REQUEST

Current Zoning: R-MH LWPA LLWPA (residential manufactured housing, Lake Wylie Protected Area, Lower Lake Wylie Protected Area)
Proposed Zoning: I-2(CD) LWPA LLWPA (general industrial, conditional, Lake Wylie Protected Area, Lower Lake Wylie Protected Area)

Approximately 10.918 acres located on the southern side of John Gladden Road, north of Wilkinson Boulevard, and west of Sam Wilson Road

The petition proposes to rezone site to I-2(CD) to develop the site for off-site parking and outdoor storage.

RZ-1.0

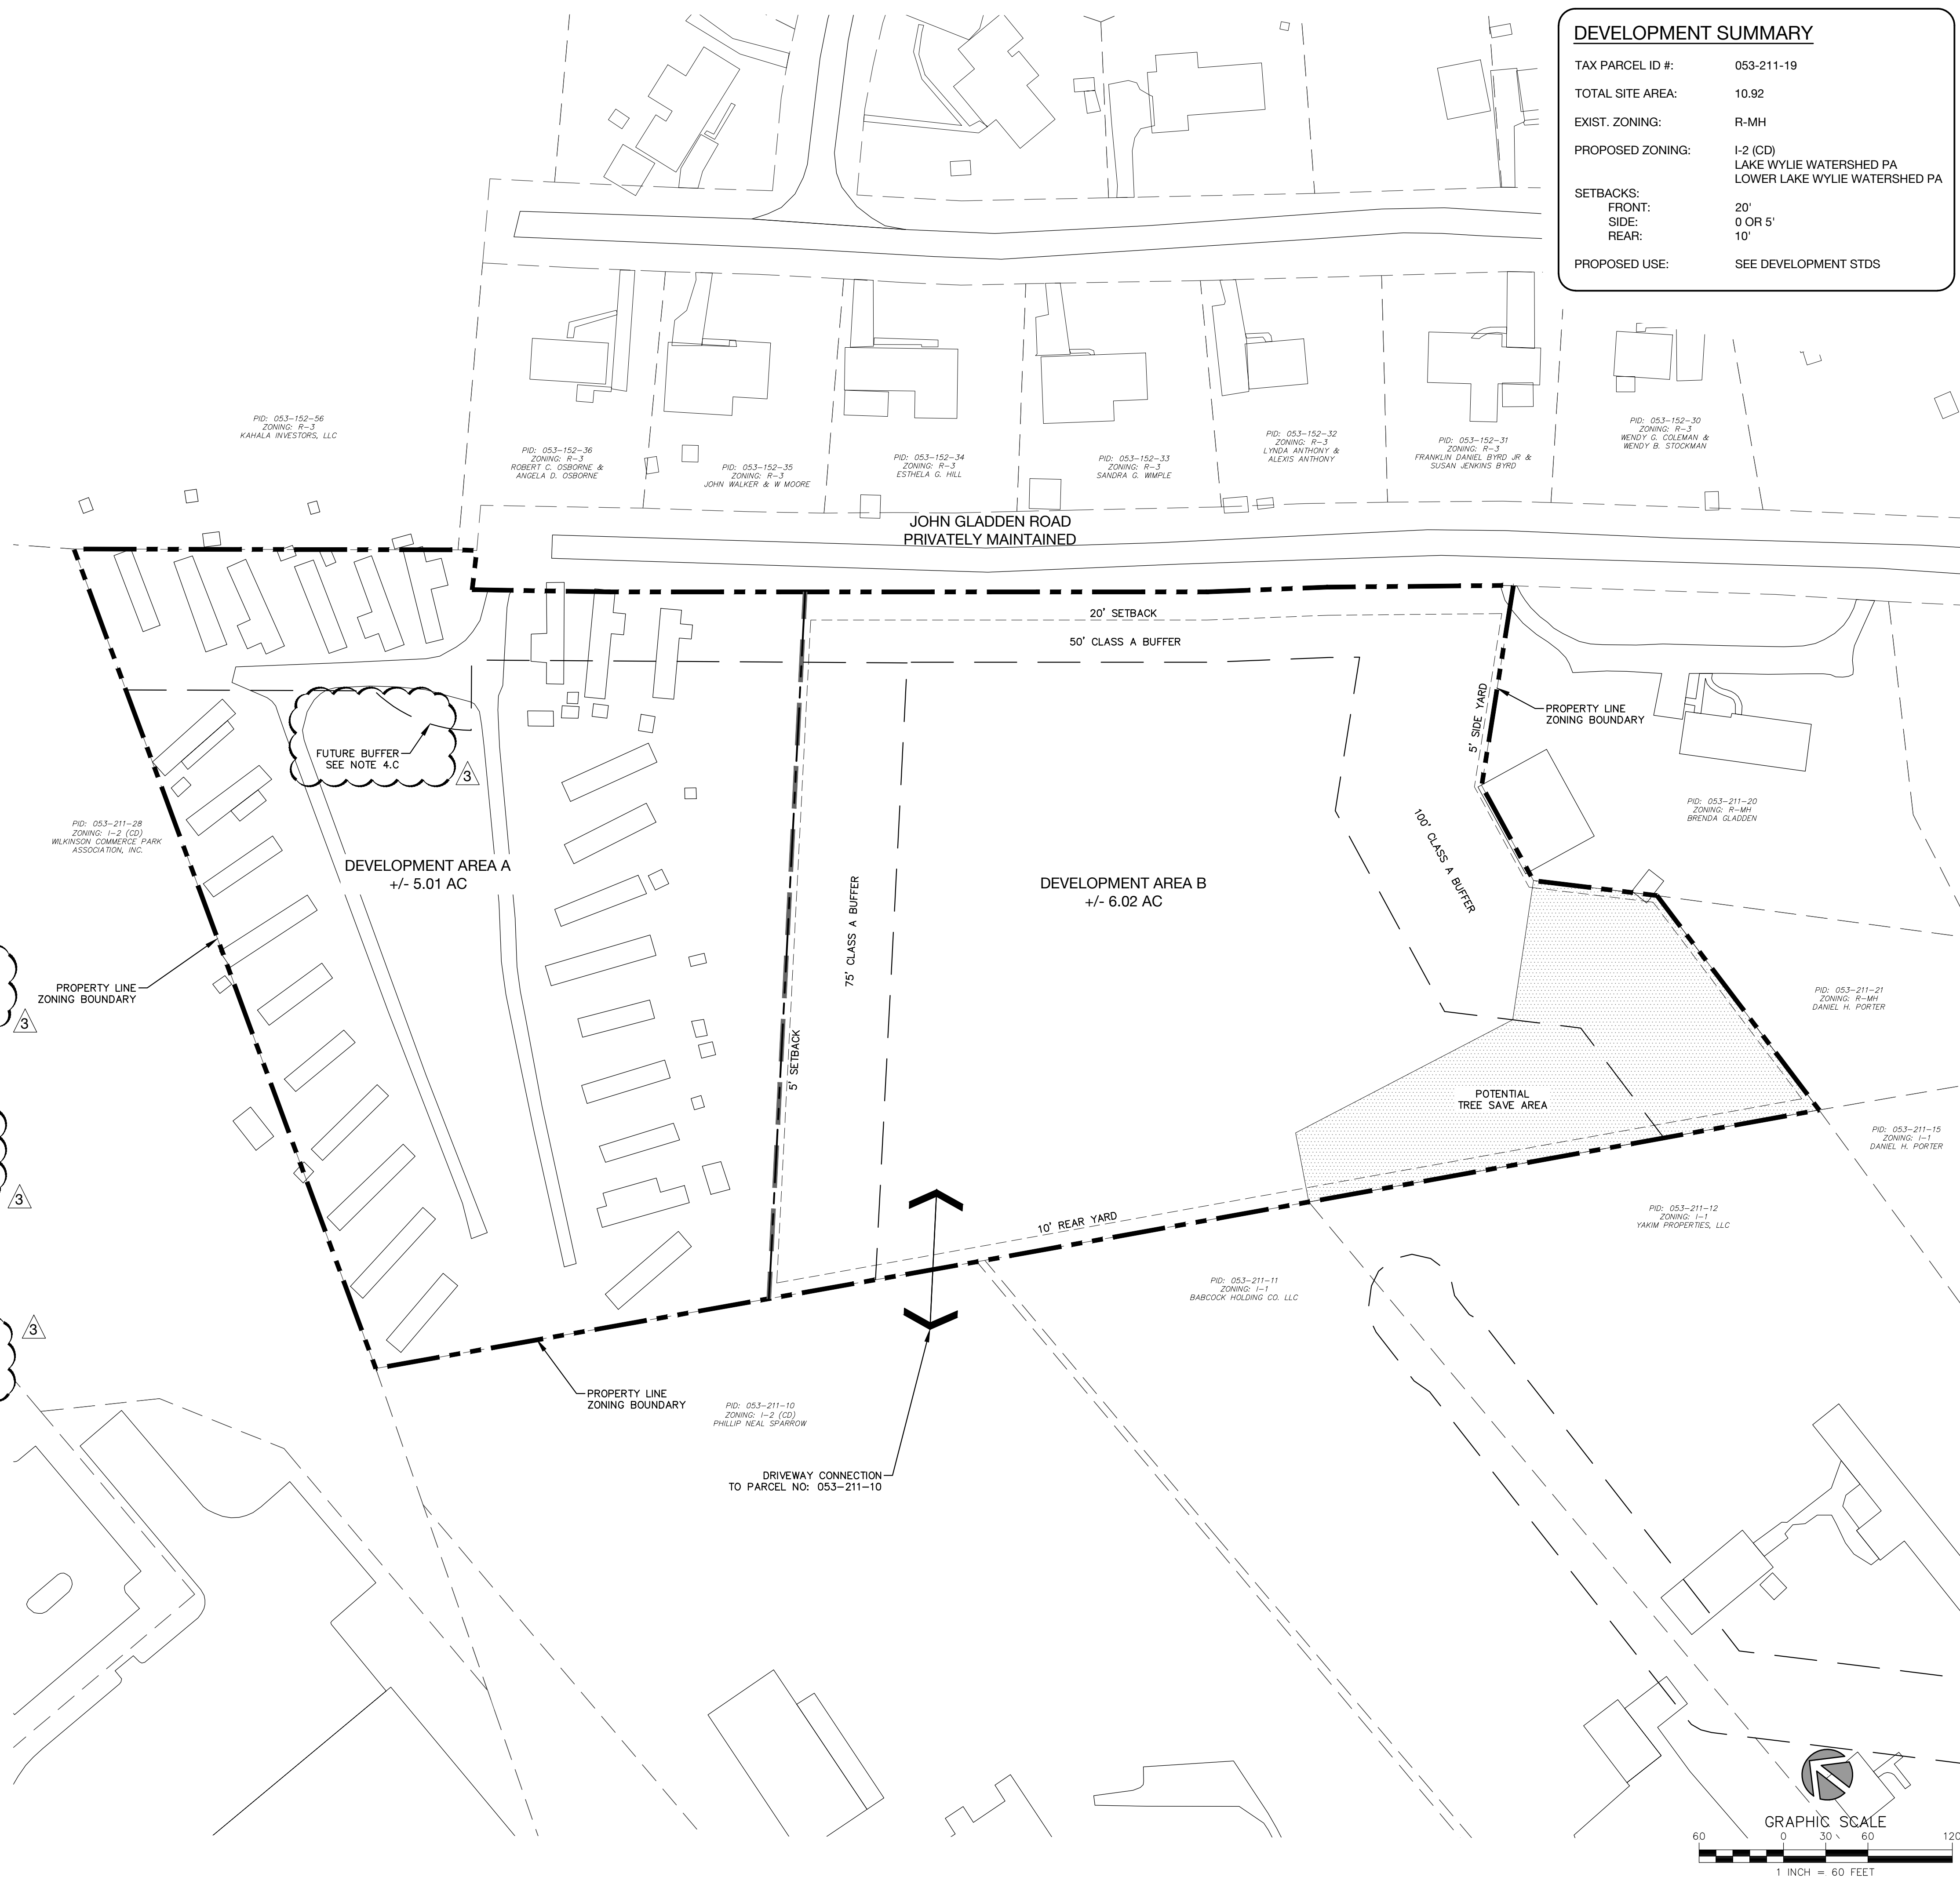
- ~~1. Will need to show required future buffer adjacent to R-3 single-family in Development Area A.~~

- ~~2. The petitioner should revise the site plan and conditional notes, in reference to Sections 3.A. and 3.B, to establish and record a cross access easement across Tax Parcel Nos. 053-211-07 and 053-211-10 to Wilkinson Boulevard. Access agreement for all three parcels in the event that one or more parcel(s) is sold to another individual/entity for access to be maintained to Wilkinson.~~

ADDRESSED

ADDRESSED
